City of Gosford Design Advisory Panel

Meeting Agenda – Design Reference Group workshop

Details	
Name	City of Gosford Design Advisory Panel – Design Reference Group (DRG)
Location	Department of Planning and Environment (DP&E) 320 Pitt Street Sydney, Level 24 Blue Gum Room (meet in foyer)
Date/Time	Tuesday 30 th July 2019, 10:30am – 12:00pm
Chair	DRG member
Attendees	Robert Hodgkins (DP&E) Louise Starkey (DP&E) Paul Walter (DRG) Peter Smith (DRG) Johann Strey Anthony Kelly
Site	Gateway Shopping Centre, 237 Mann Street, Gosford

Internal Section C

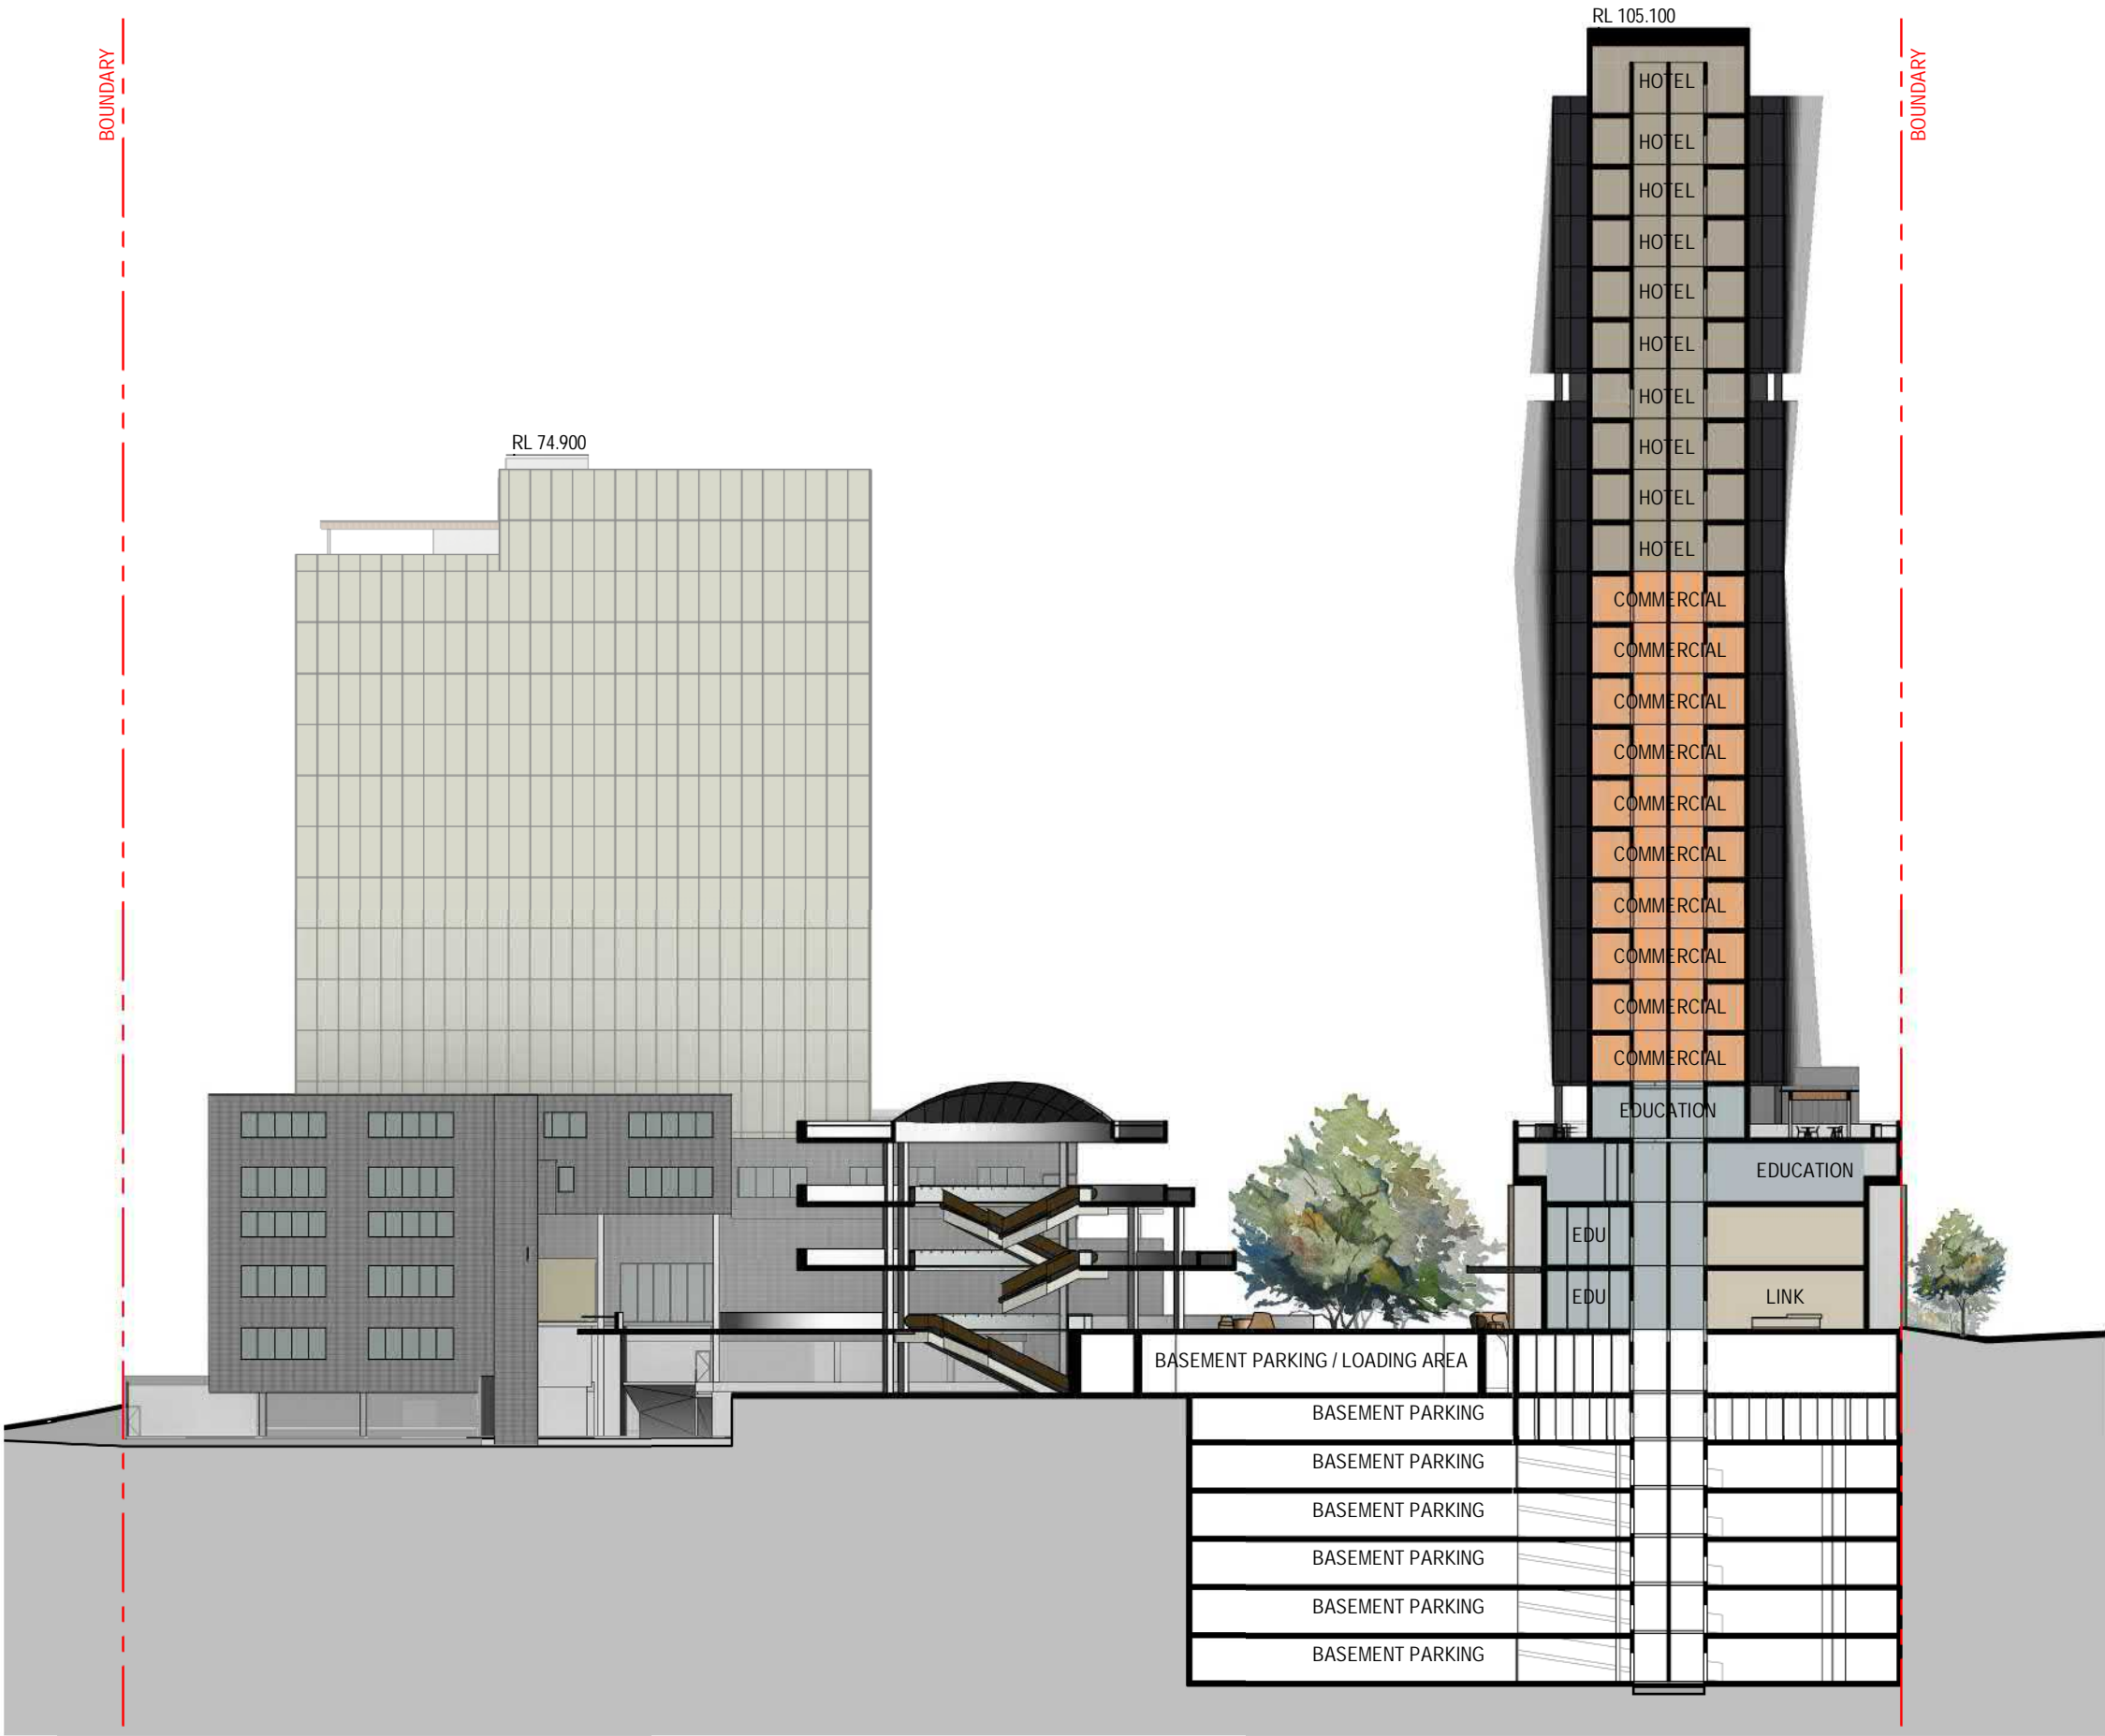
- Is there sufficient privacy separation between the student living and retirement,
- How does the shadow cast by the student housing impact solar access to the retirement
